EL PASO COUNTY PARKS DEPARTMENT | PARK PLANNING DIVISION

Subject: **Falcon Reserve Final Plat (SF-26-017)**

The Park Planning Division of the El Paso County Parks Department has reviewed the submittal of the Falcon Reserve Final Plat development application and has the following preliminary comments on behalf of El Paso County Parks. This application, along with the following comments and recommendations, will be presented to the El Paso County Park Advisory Board for consideration and endorsement on September 9, 2026:

FINAL LANDSCAPE
PLAN

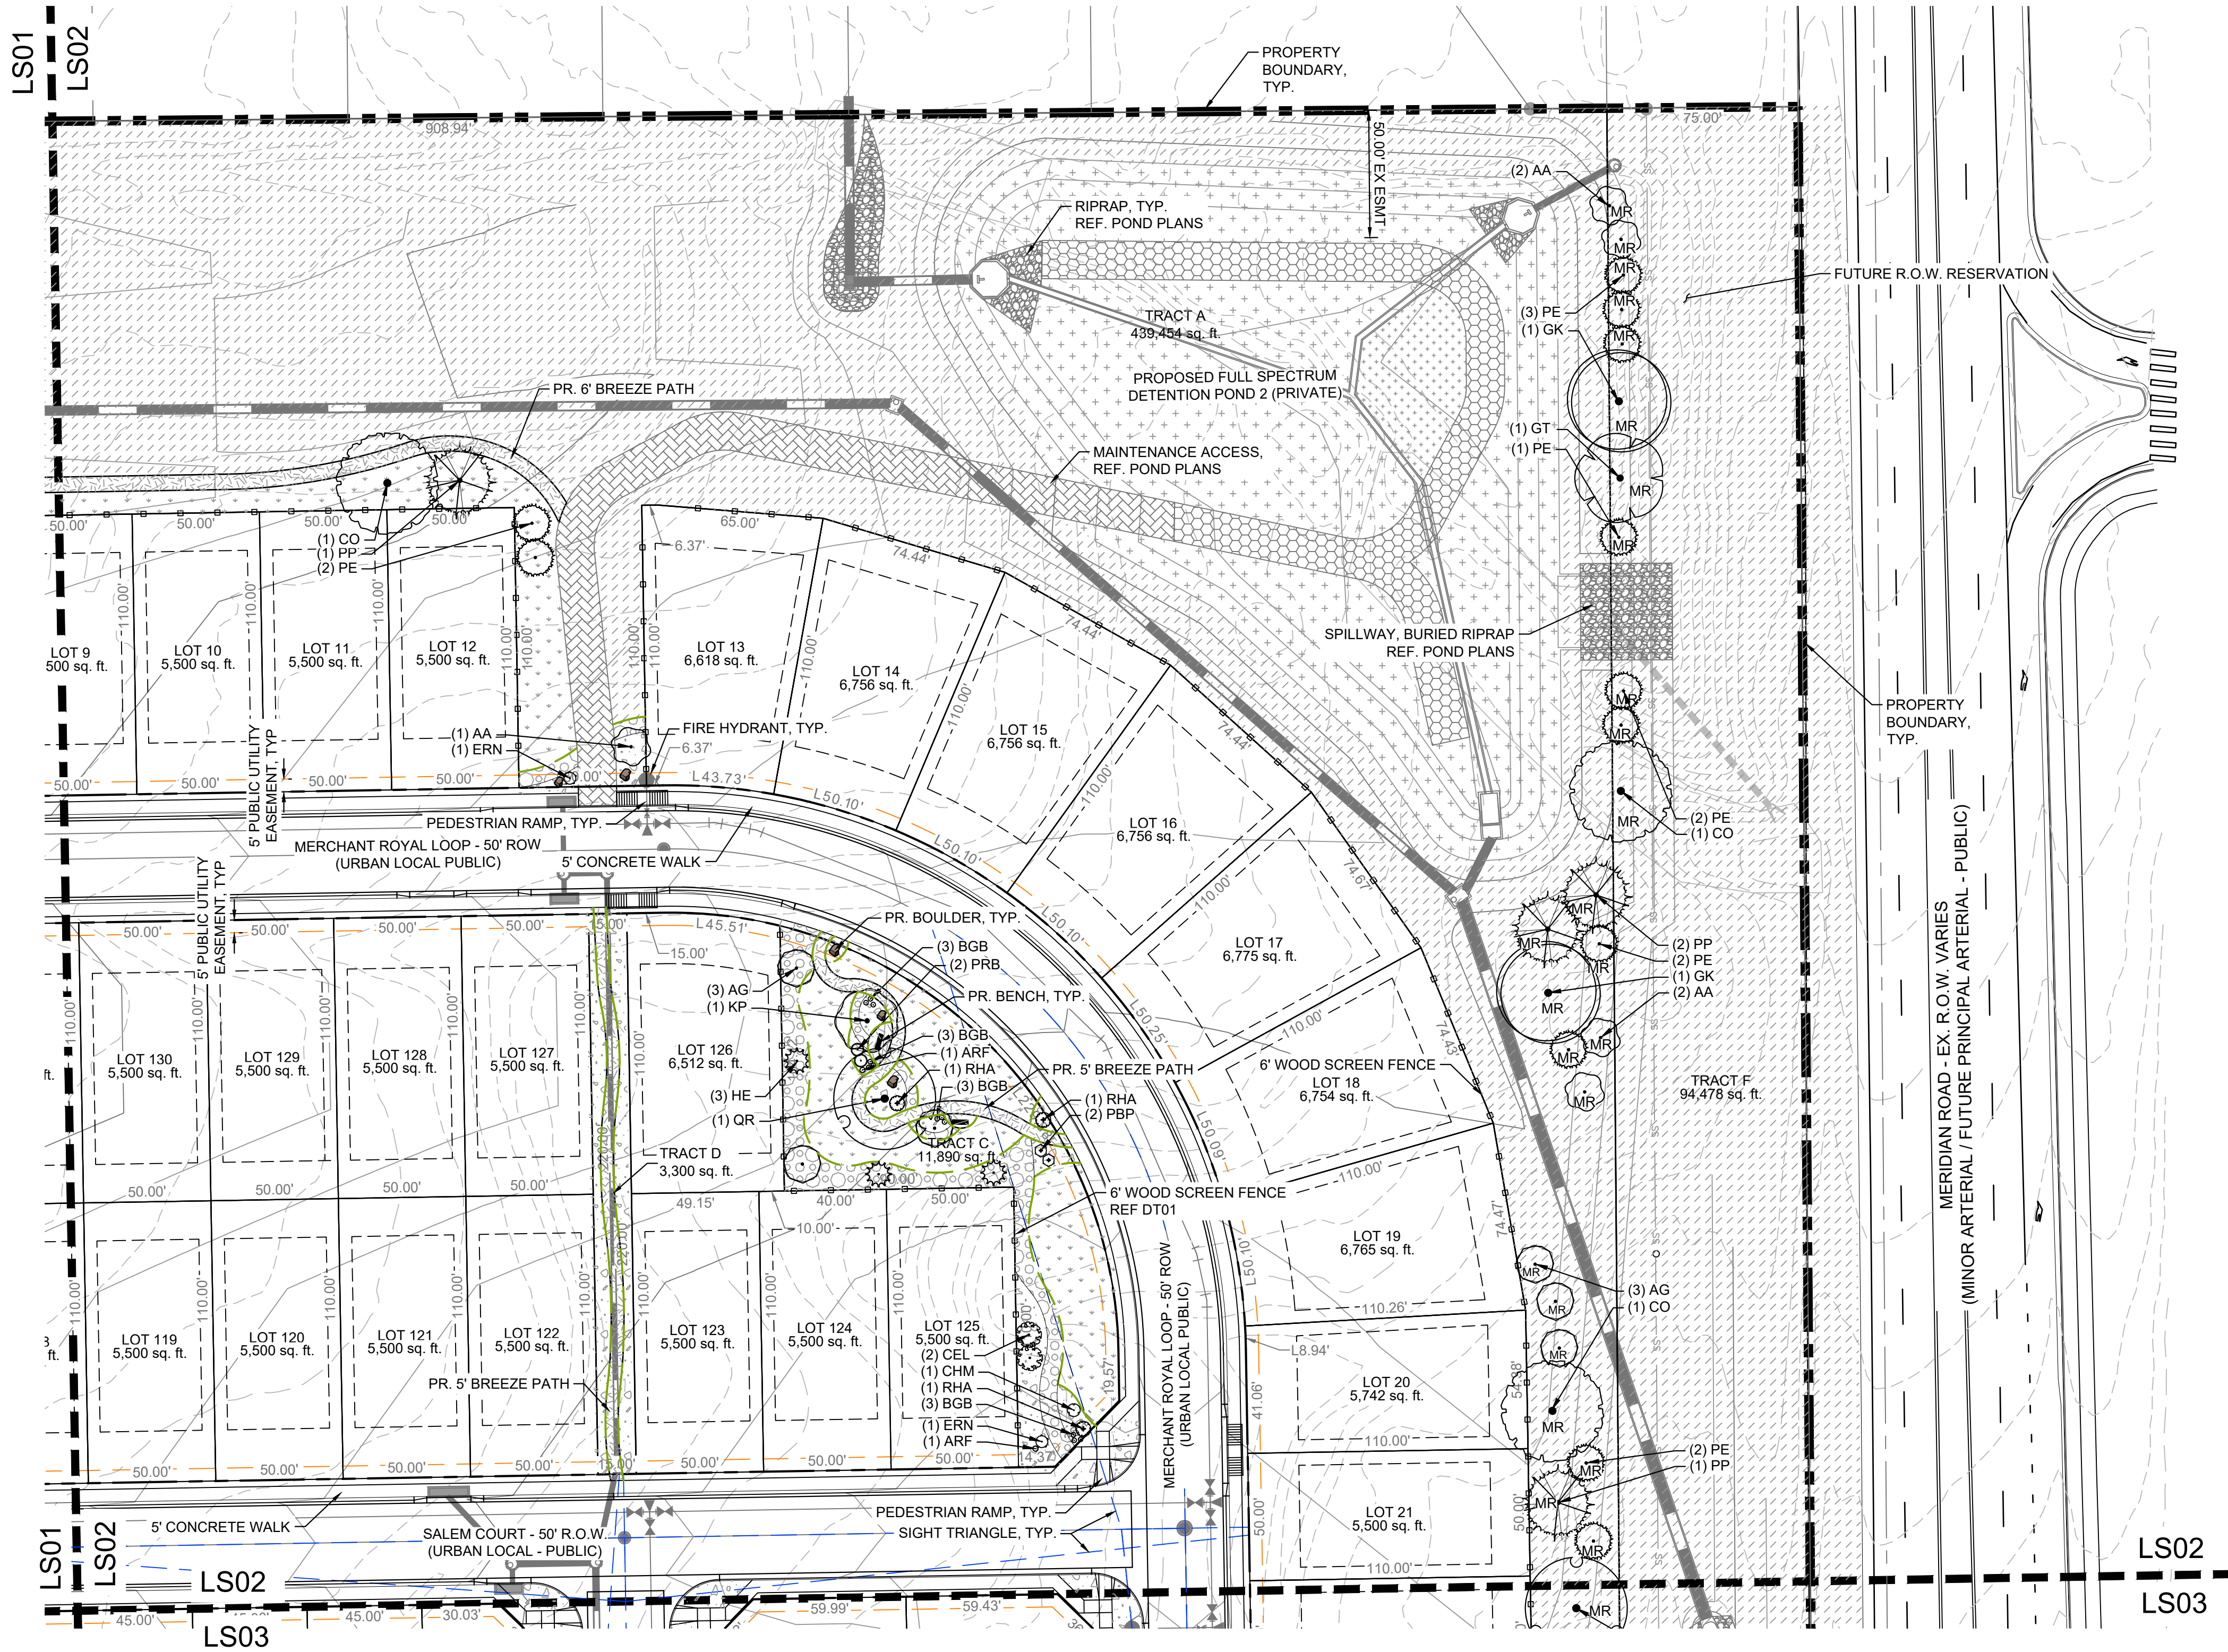
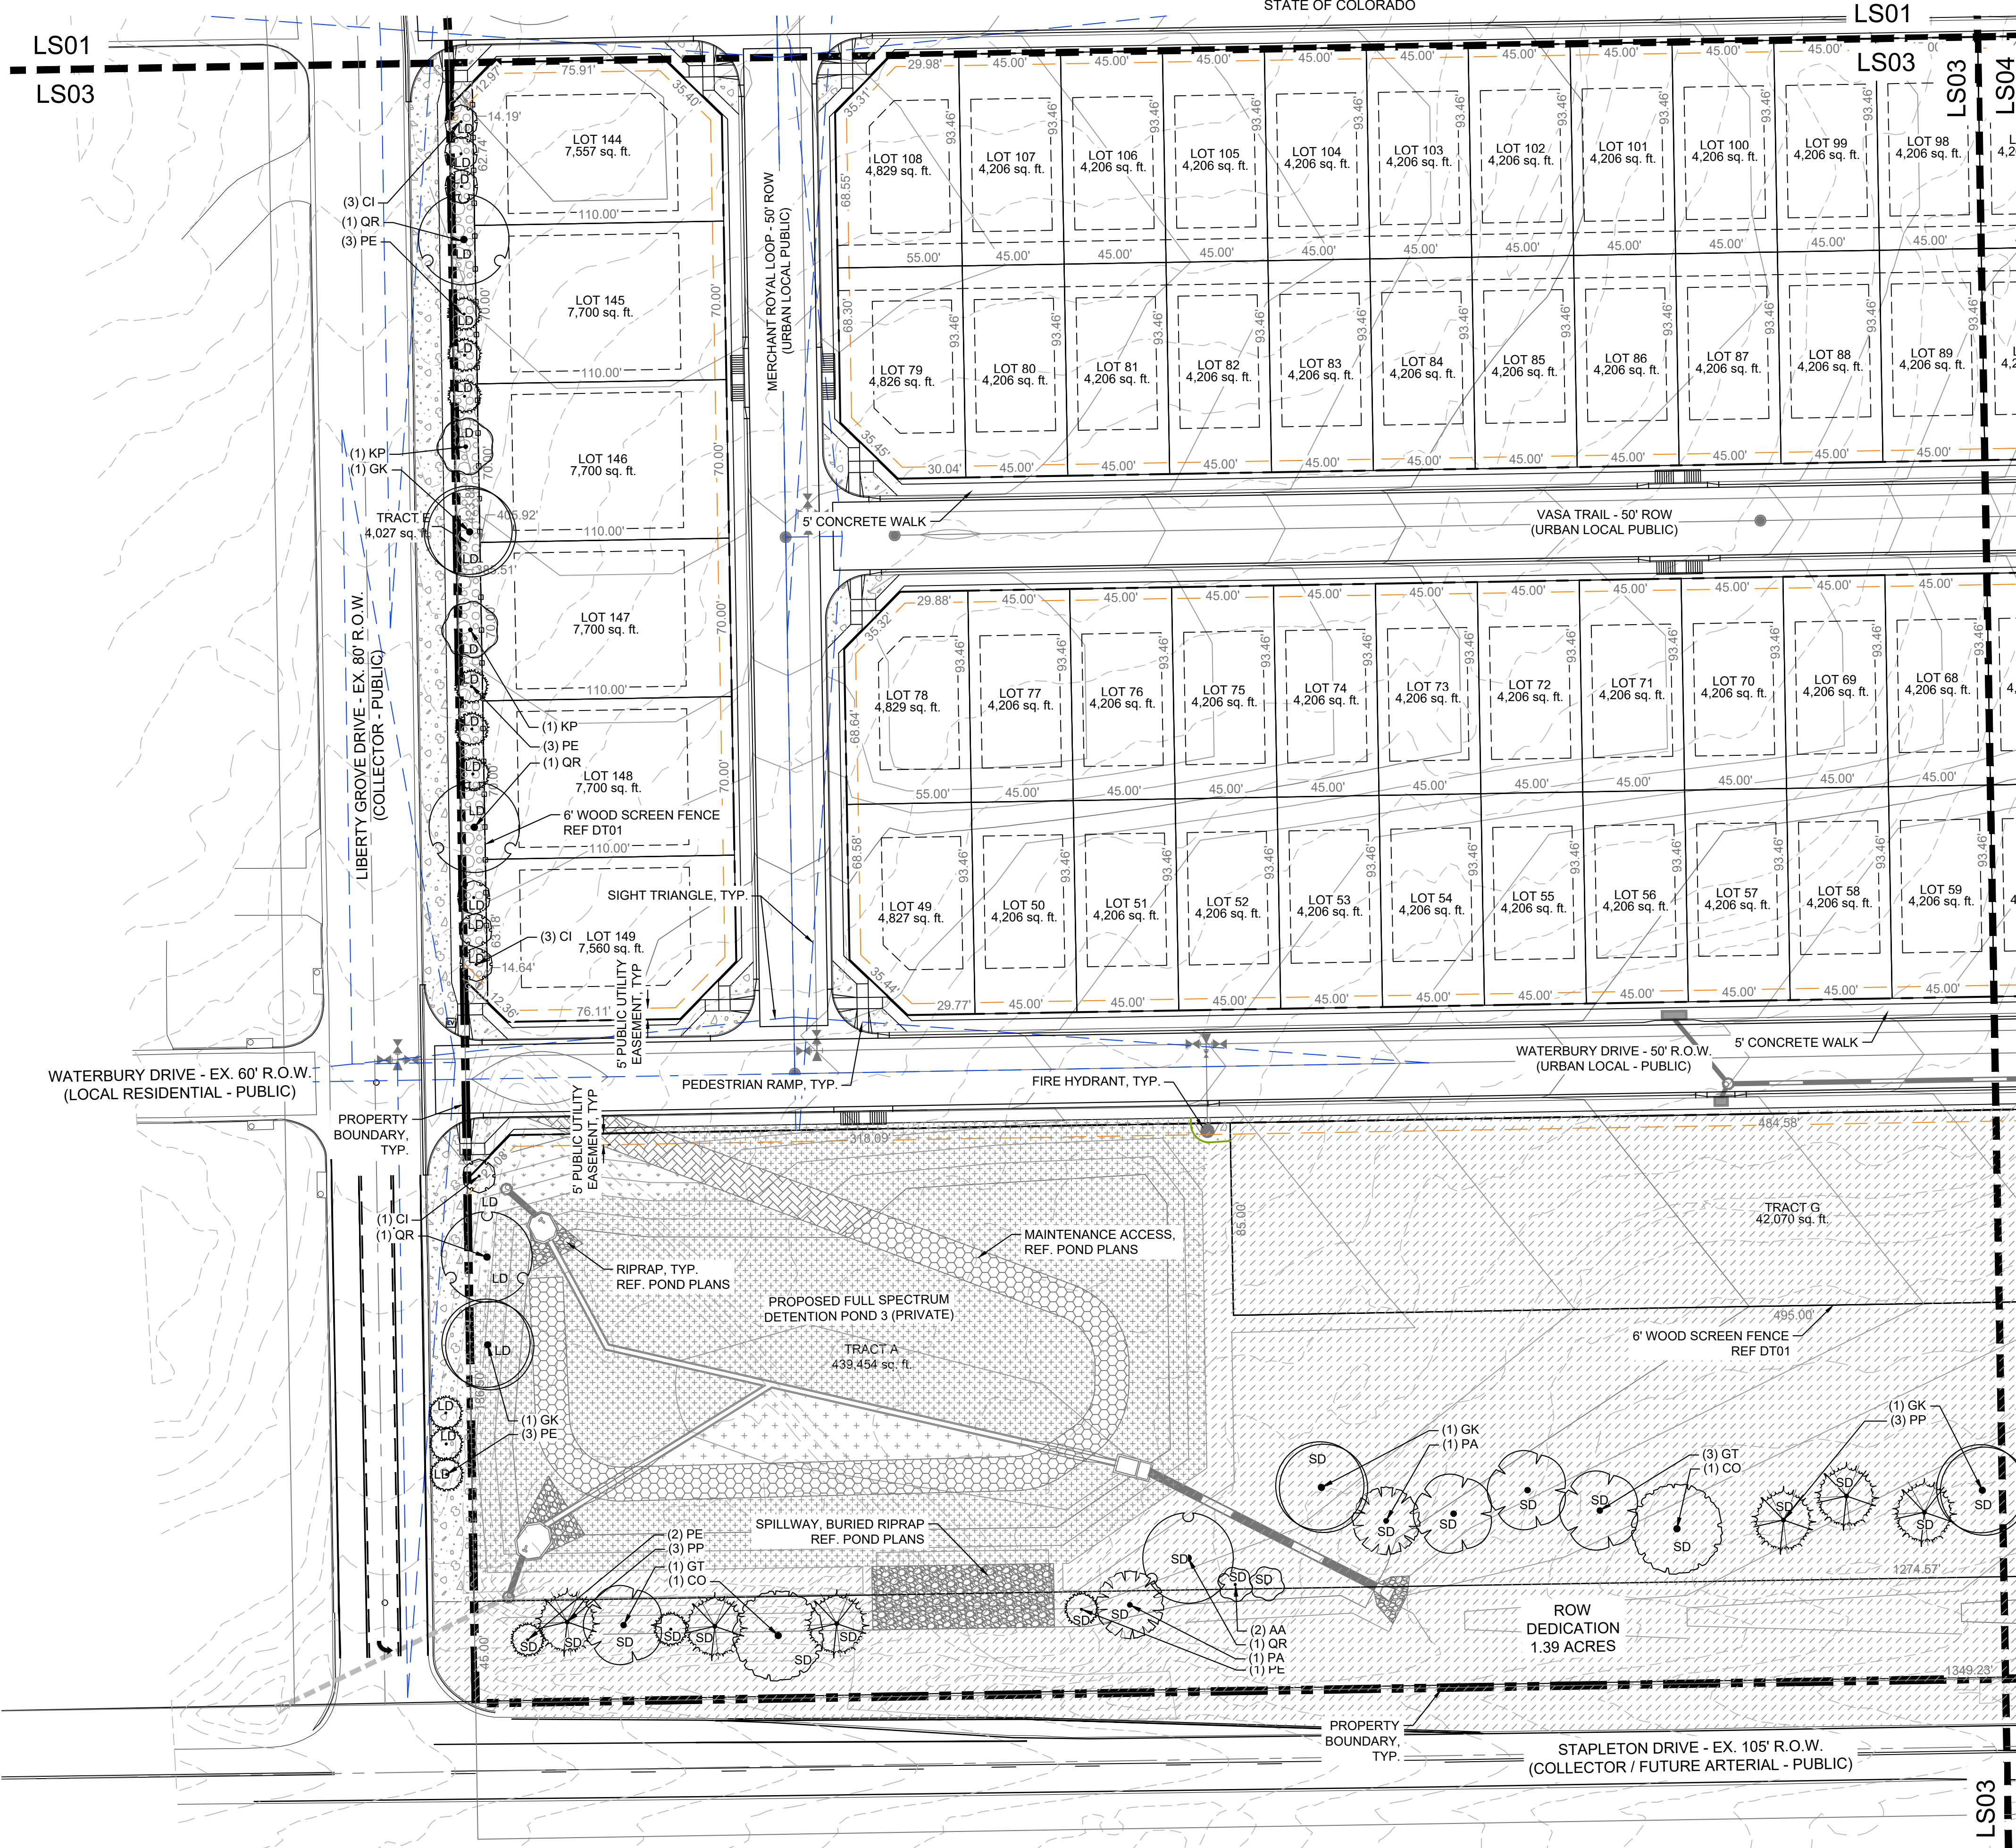
Upon review of the Final Plat and Letter of Intent, staff notes that the letter of intent document does not reference the 2022 El Paso County Parks Master Plan. Additionally, the proposed neighborhood park within Tract B, which was discussed and depicted with the Preliminary Plan, is currently depicted within the letter of intent, landscape plans, and noted on page one of the final plat. The proposed park site will provide valuable recreational benefits to the residents of Falcon Reserve and should therefore remain an integral component of the overall development plan.

Staff acknowledges the proposed 6-foot breeze path. Consistent with comments provided during the Preliminary Plan review, staff further recommends that the breeze path be extended along the eastern and southern portions of the development within the landscaped open space areas. This extension would provide an additional, cost-

effective recreational amenity for the residents and visitors of Falcon Reserve while enhancing connectivity throughout the development.
